NSW RURAL FIRE SERVICE

Your reference: MP08_0194 Mod 3
Our reference: D11/0019
DA15111099299AB

Agency Comment Kings Forest Project Approval, Tweed Coast Road, Kingscliff - Modification 3 Kings Forest Service Station

Scale	Date	Job Number	
1:2500@A3	NOV 2015	738.12	
Drawn	Stage	Drawing No.	Issue
PN	DA	0000	E

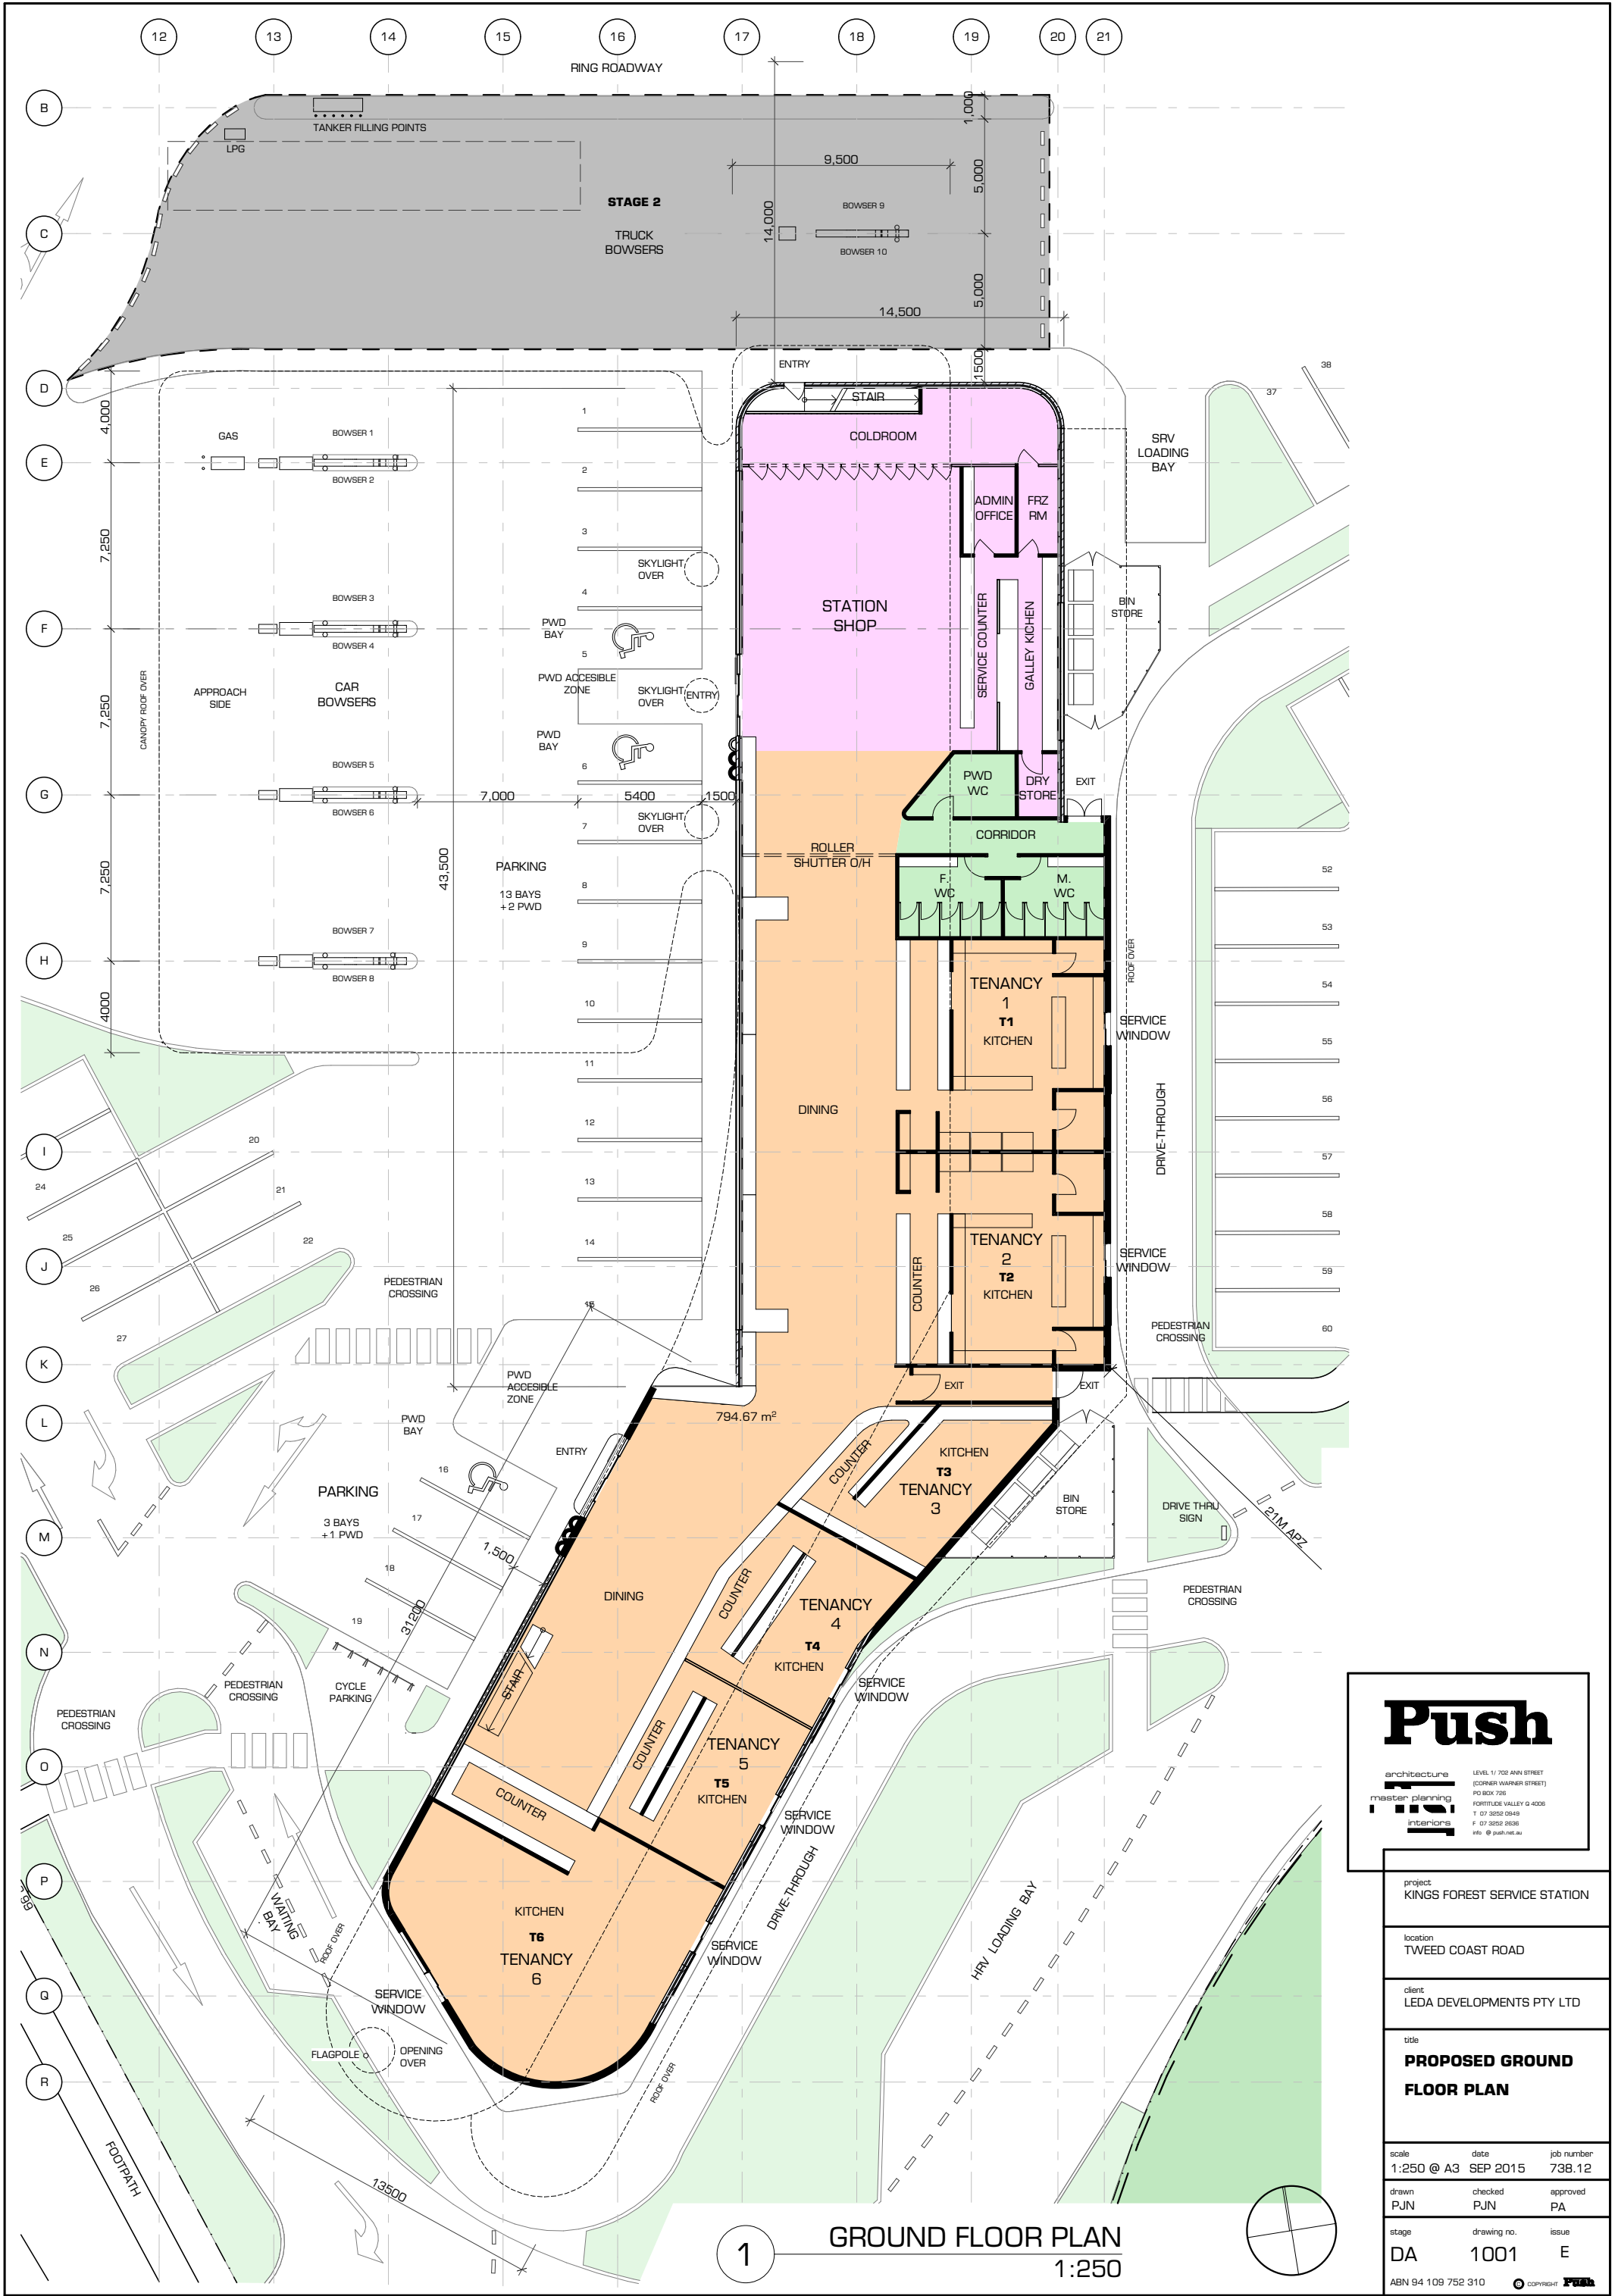
- The proposed tanker filling points, including above-ground ventilation infrastructure, should be located a minimum 7 metres from the north boundary and be designed to withstand 25 kWm² of radiant heat exposure;
- The proposed truck bowzers (stage 2) should be located a minimum 7 metres from the northern boundary and be designed to withstand 25 kWm² radiant heat exposure;
- No storage of any materials should be permitted within 7 metres of the northern boundary;
- At the commencement of building works and in perpetuity the land around the Service Station building for a distance of 21 metres or to the property boundary, shall be managed as an inner protection area (IPA) as outlined within section 4.1.3 and Appendix 5 of 'Planning for Bush Fire Protection 2006' and the NSW Rural Fire Service's document 'Standards for asset protection zones';
